Rezoning Transportation Analysis

Petition Number: 2023-164

Date	Description
1-24-24	First Review (JP)
2-21-24	Second Review (JP)
3-20-24	Third Review (JP)

DRAWING NO.: **RZ-01**

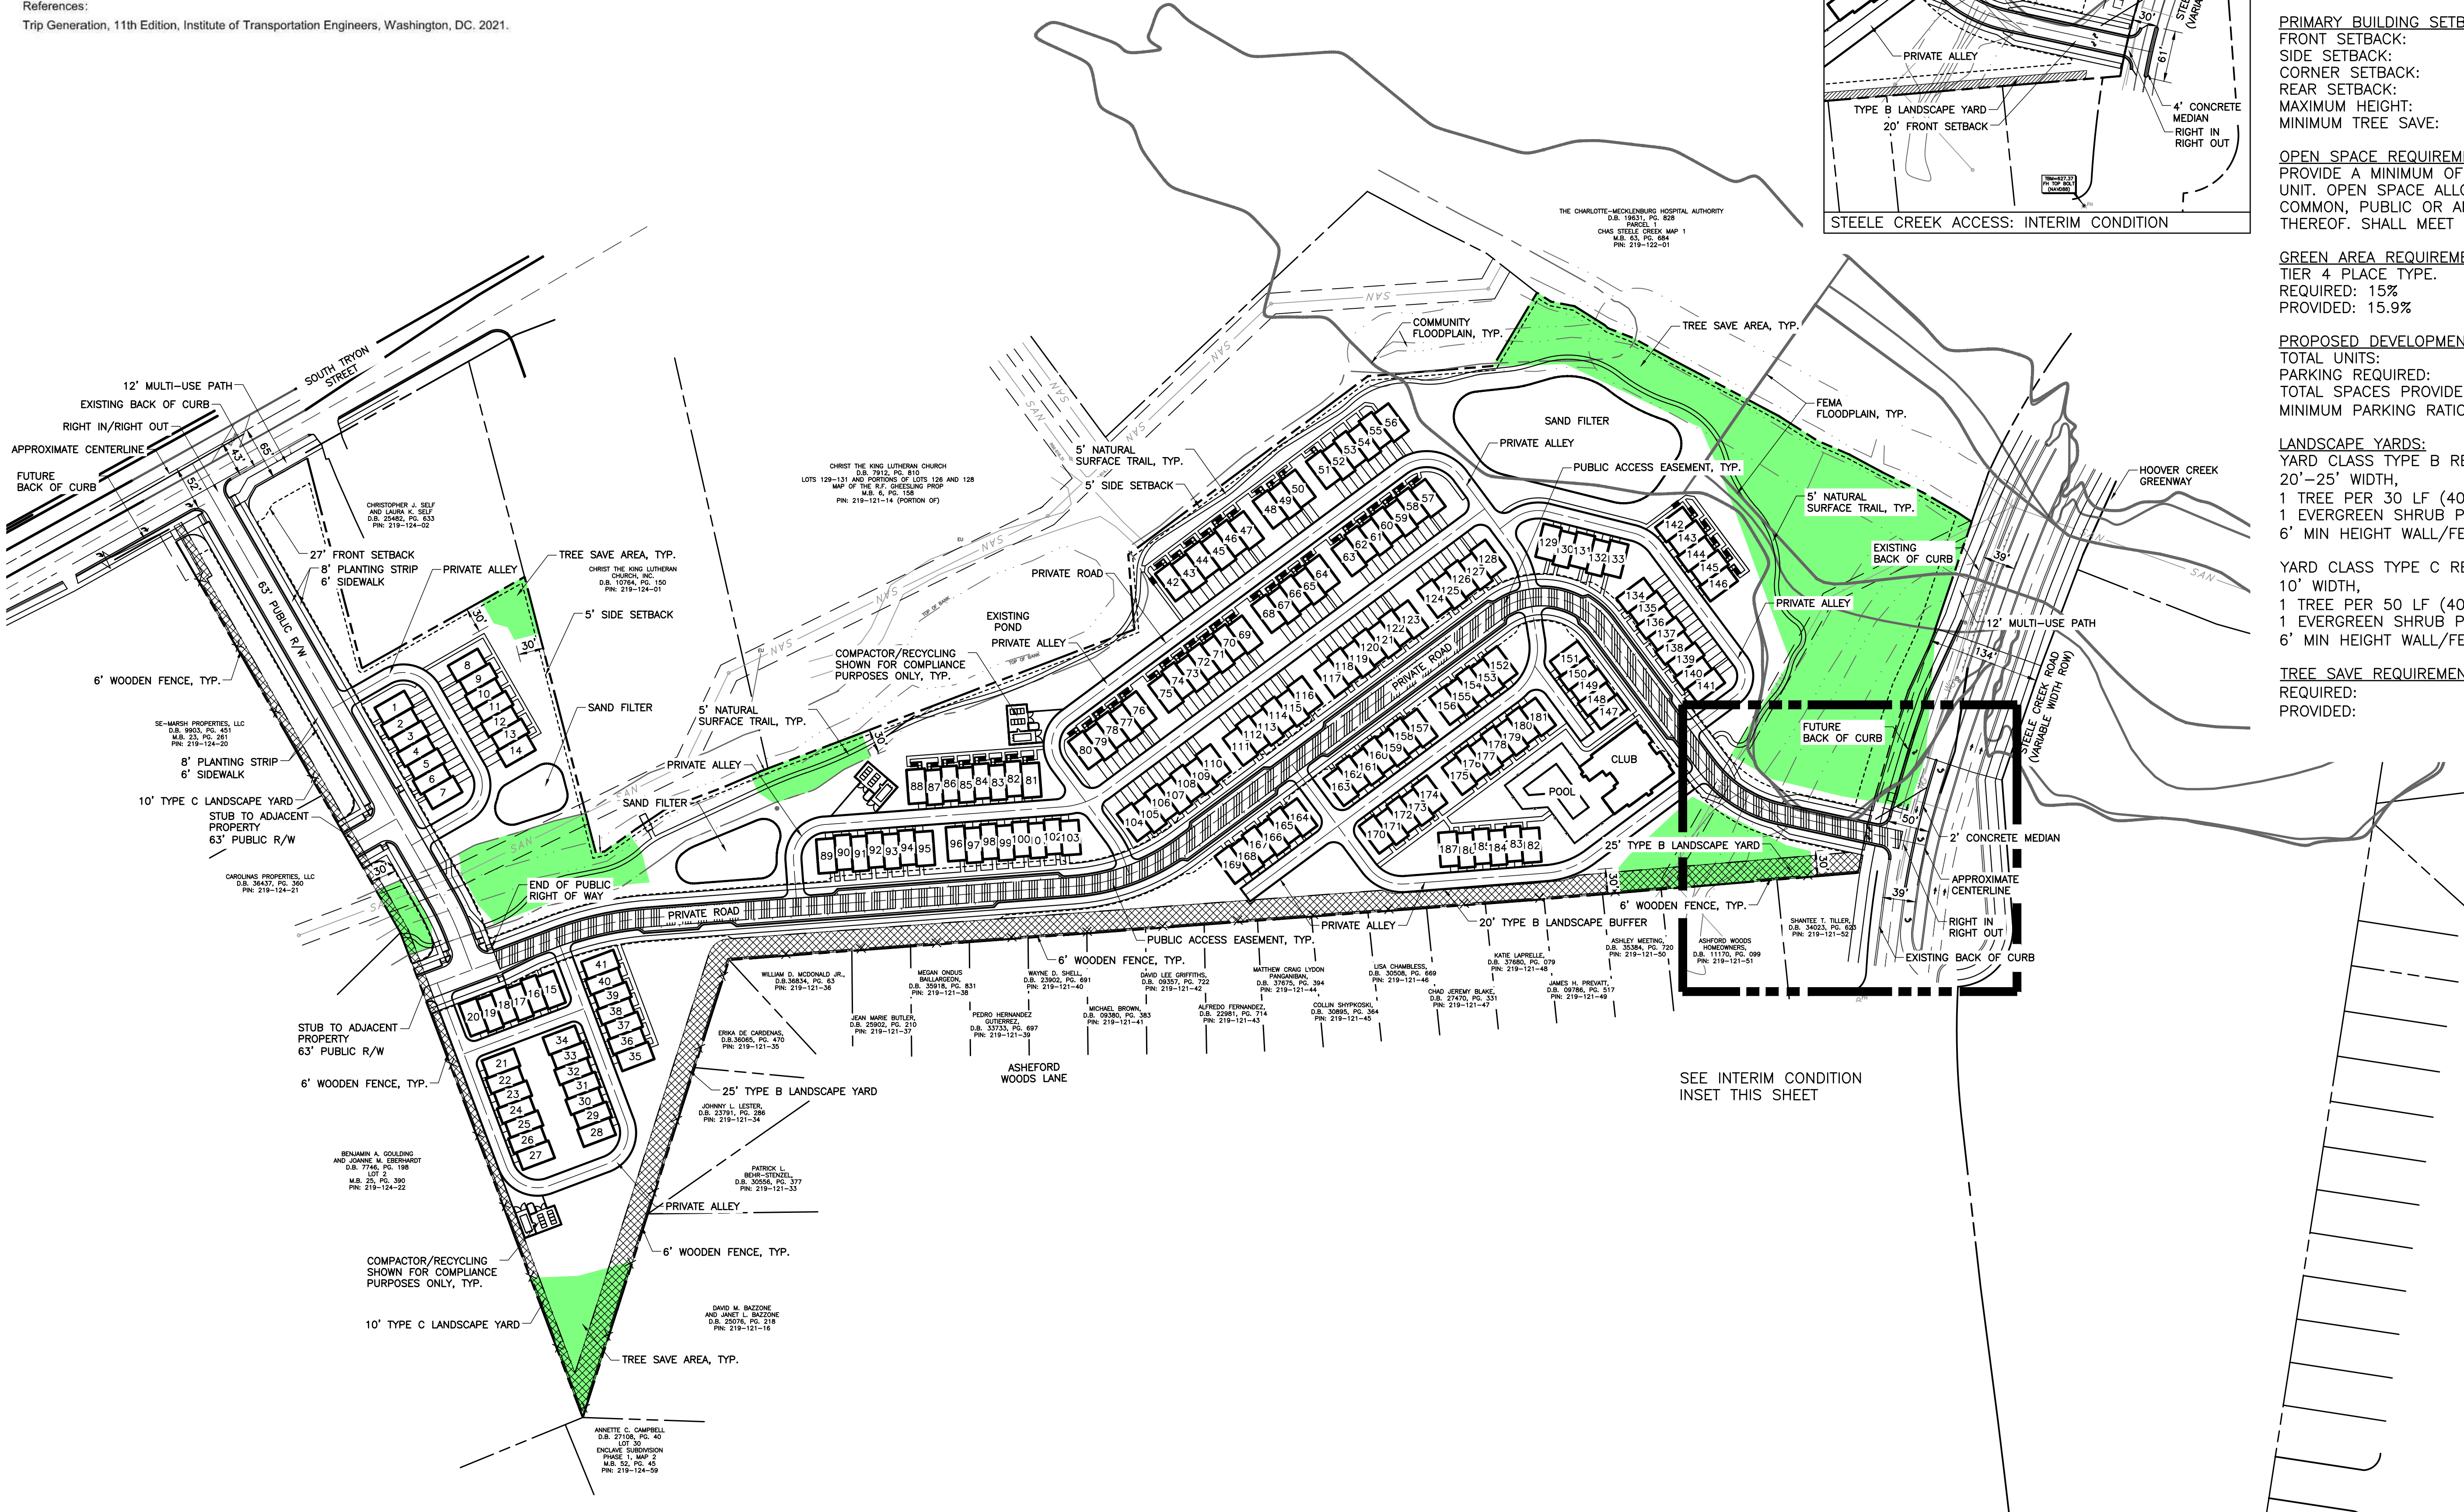
Outstanding Comment 2.21.24: Label and dimension the curb and gutter from the centerline for each road on the site plan.

4. Revise site plan to show interim condition on Steele Creek Road and screen in the final condition to be installed by NCDOT as part of the Steele Creek Widening Project.

Clarifying Comment 2.21.24: Callout concrete median on Steele Creek Road on the inset. Label and dimension the median length.

Clarifying Comment 3.20.24: Median should be shown to extend to 50' past radius returns at the new street connection.

5. Revise site plan to shift Tryon Street access further from existing driveway.

8. ~~New Comment 2.21.24:~~ ROW should not be terminating in the middle of the road. Continue the ROW to the end of the street, capturing the street stubs.

~~Clarifying Comment 2.21.24:~~ Revise site plan to call out the public access easement. Use a different line type for easement versus ROW.
